JBA Consulting Stormwater Audit Stage 1 - Rev 1 Project: Residential Development at St Teres's, Temp

Residential Development at St Teres's, Temple Hill Rd, Blackrock Project Nr. Date: 2019s0083 22/09/2021 JBA Reviewers Chris Wason - Principal Engineer

Drawing Title
SOAKAWAY TEST LOCATIONS

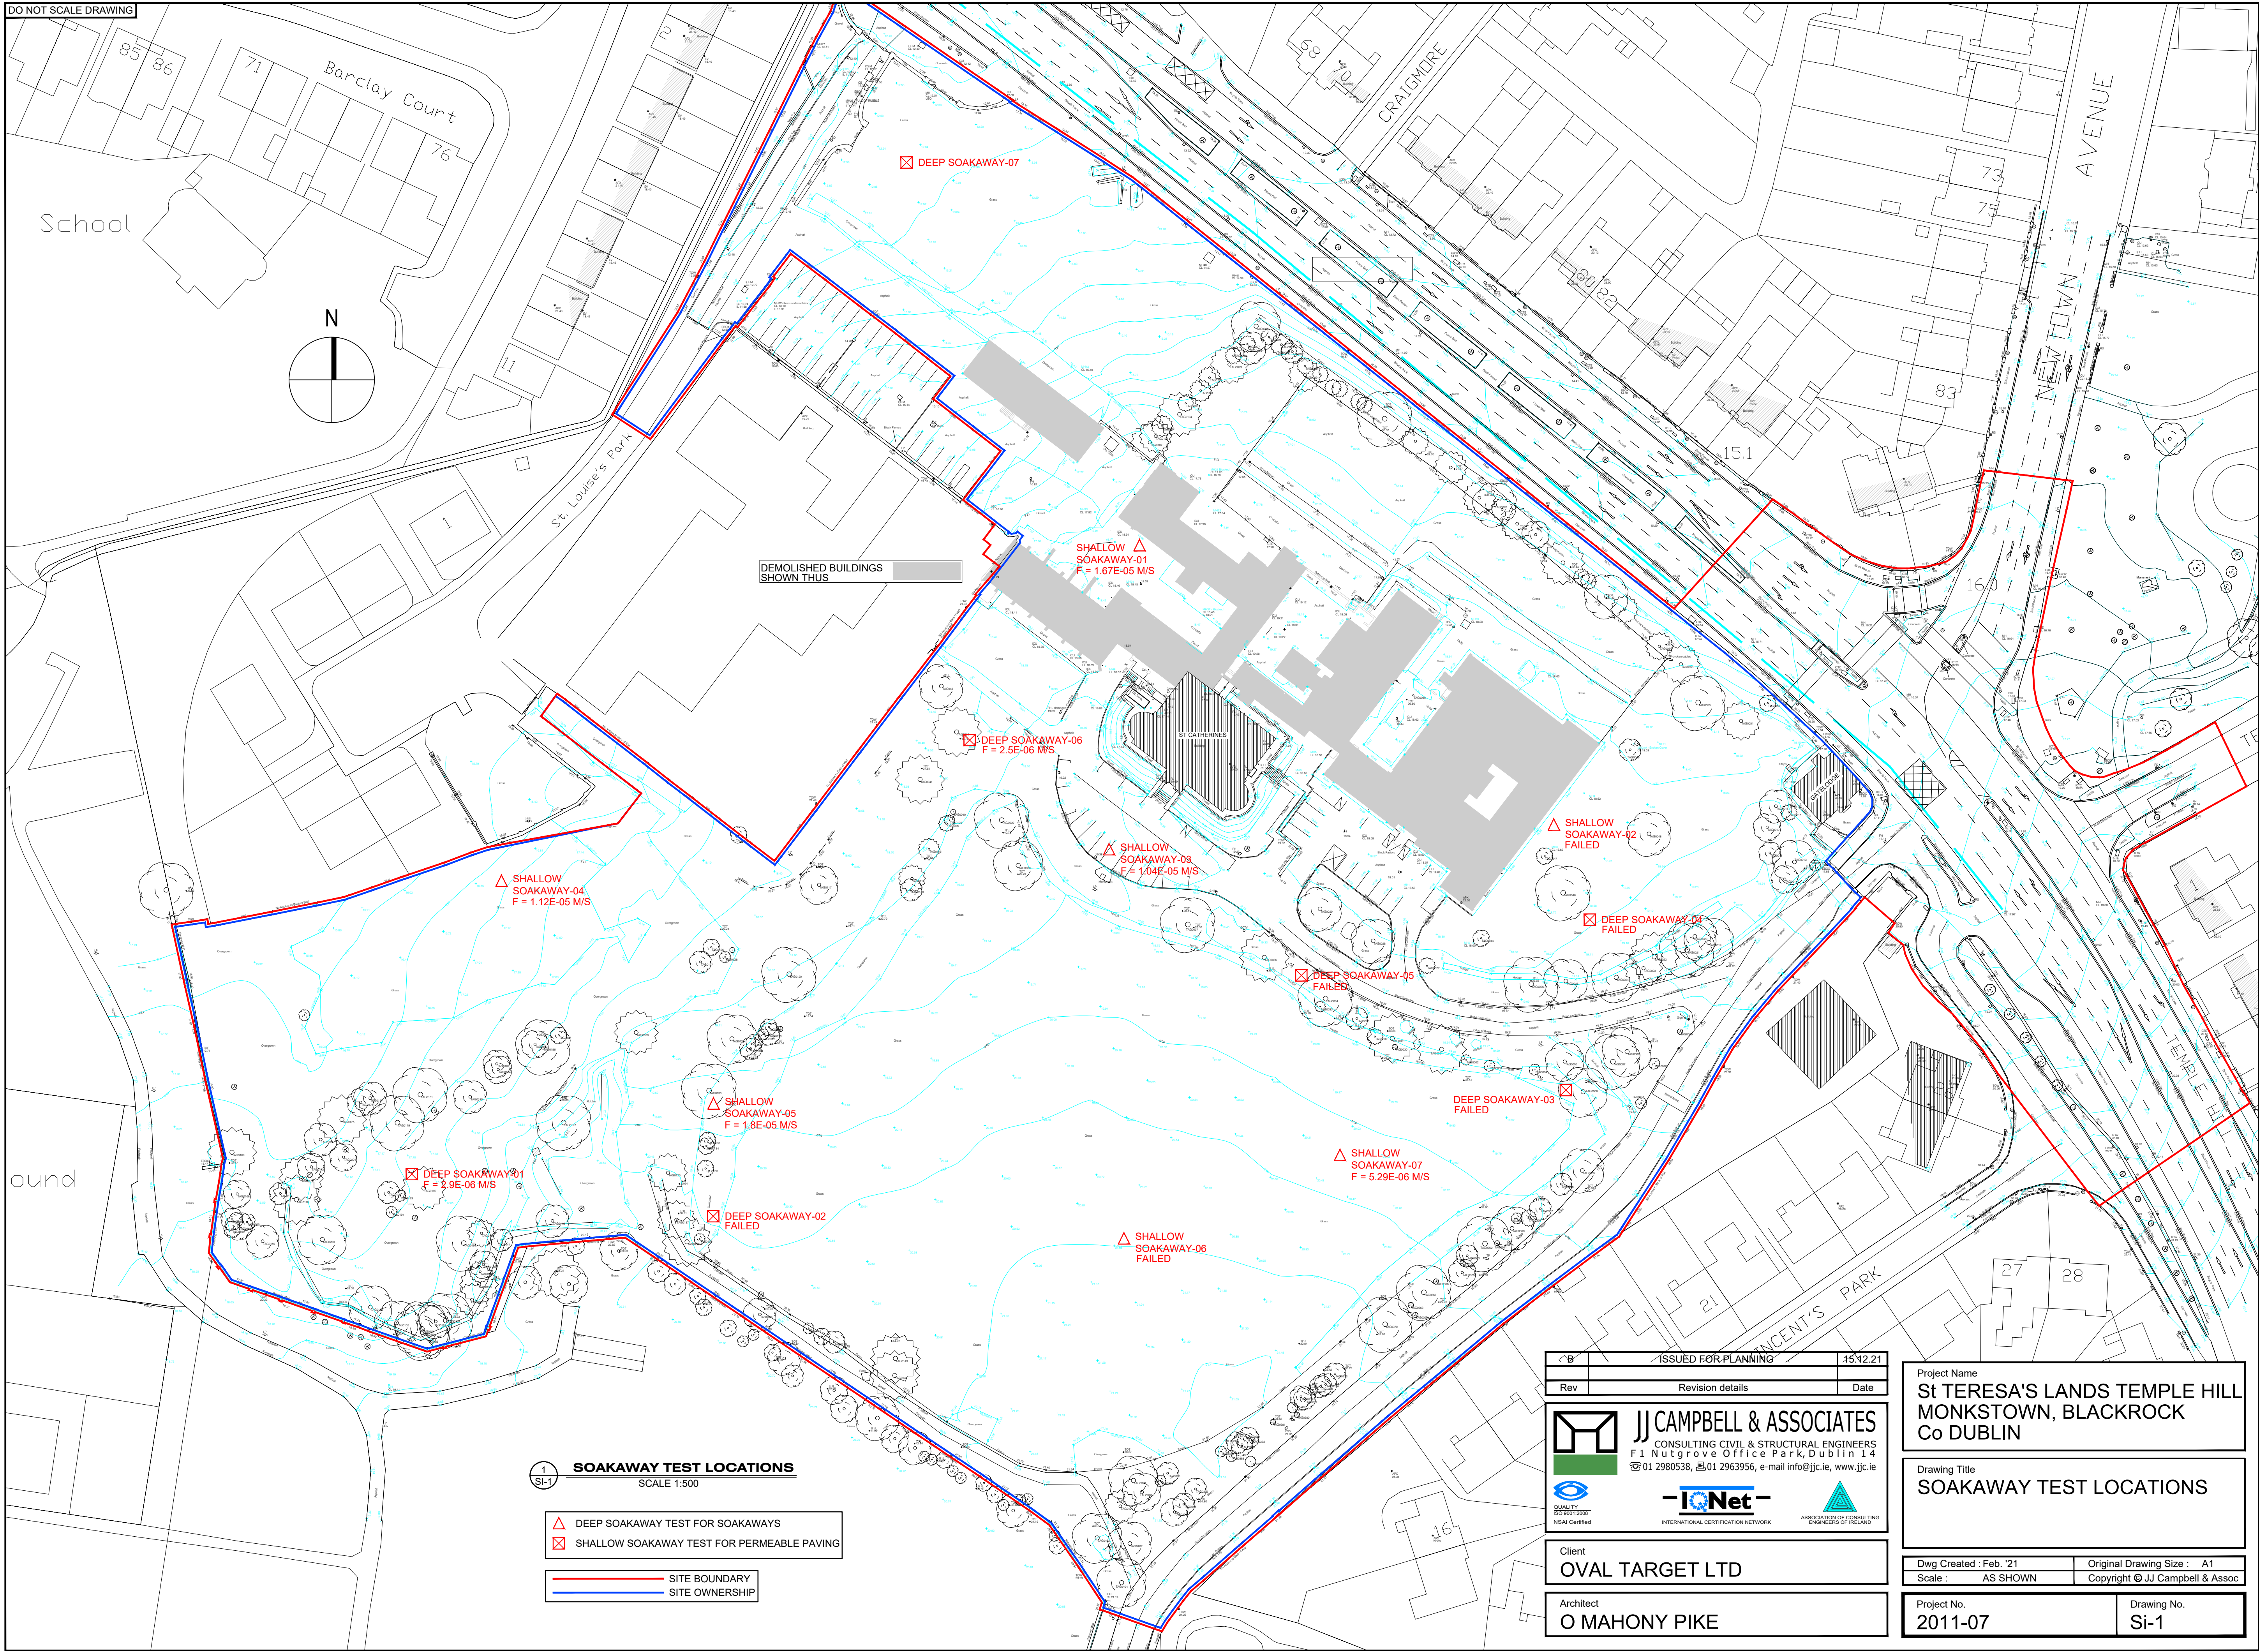
Item No.	JBA Review Comment	Comment/Clarification Request/Suggested Mitigation	Response from Client/Client Representative	Acceptable / Not Acceptable
3	Filter drains	the use of filter drains/trenches will assist in the interception	We will review the use of filter drains at detailed design stage. The mature trees being retained make the wide spread use of filter drains difficult.	Accepted
	The full extent of the drainage network has not yet been fully designed and	of runoff and could be considered in the detail design phase .	Similar issue arise with the traditional pipe drainage which had to be designed to avoid the heavily rooted areas.	
	detailed. Consideration could be given for the use of filter drains where	Can consideration could be given to soakaways in some areas		
	possible.	of the site where ground conditions are more suitable?	Infiltration tests indicate that the site is not suitable for soakaways.
